CITY OF ALBUQUERQUE

RE: **Rain Tunnel Car Spa**
5401 Sevilla Ave
Grading and Drainage Plan
Engineer's Stamp Date 5/17/17 (File: F11D016)

Based upon the information provided in your submittal received 5/18/17, the Grading and Drainage Plan cannot be approved for Administrative Amendment to the Site Plan for Building Permit until the following comments are addressed:

Proposed SD Outfall

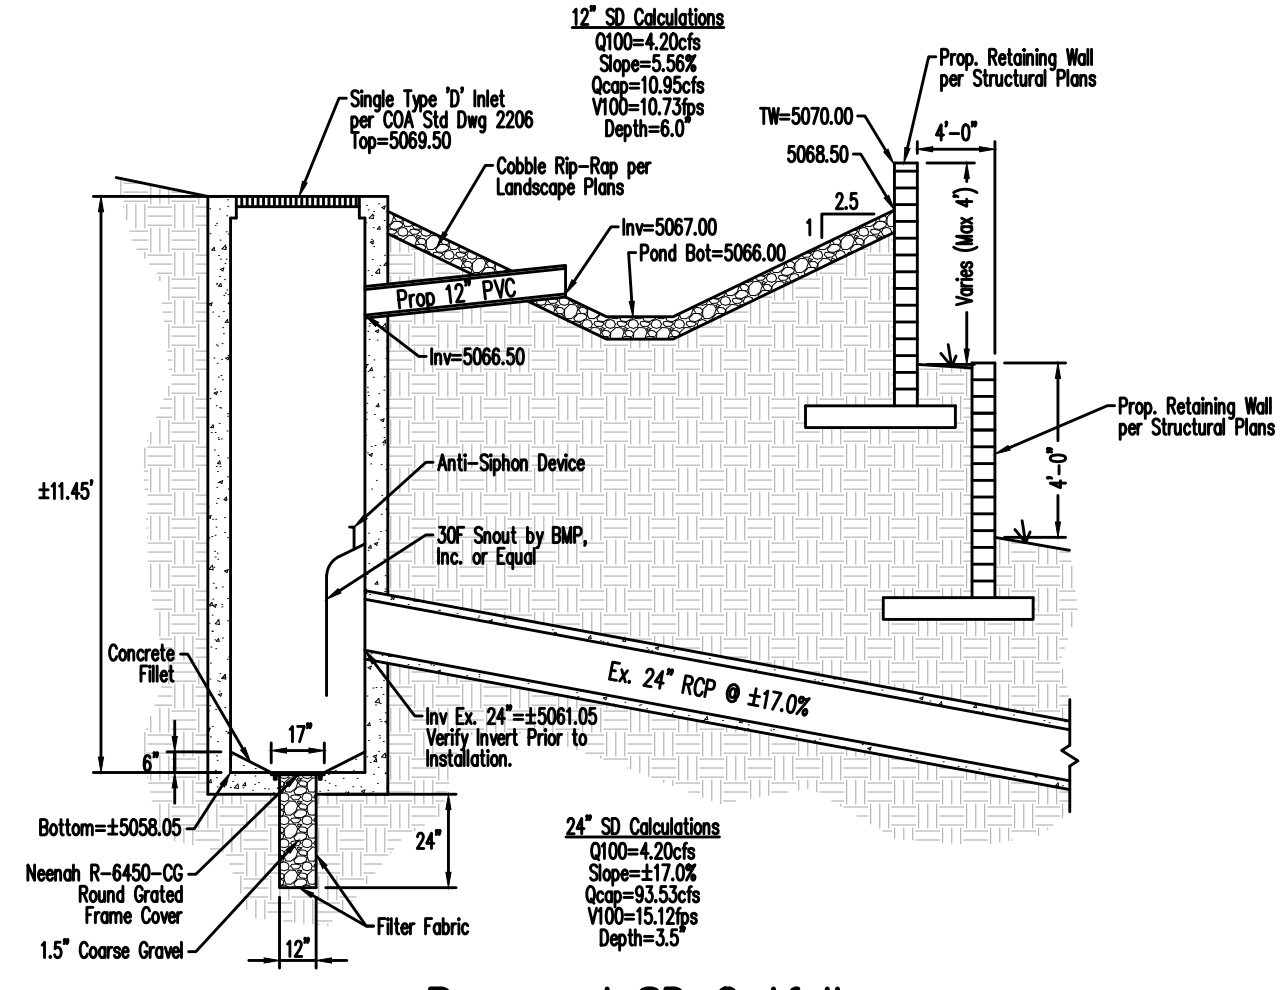
1. Provide details for the tie-in to the existing double-D inlet, including invert in/out, grate, and any required adjustments.
2. Provide details for pond outfall, including the outlet structure and pipe. Include flow, velocity, and HGL with the pipe profile.
3. The Grading and Drainage Plan for Site Plan for Building Permit needs to be clearly labeled as 'Not For Construction.'
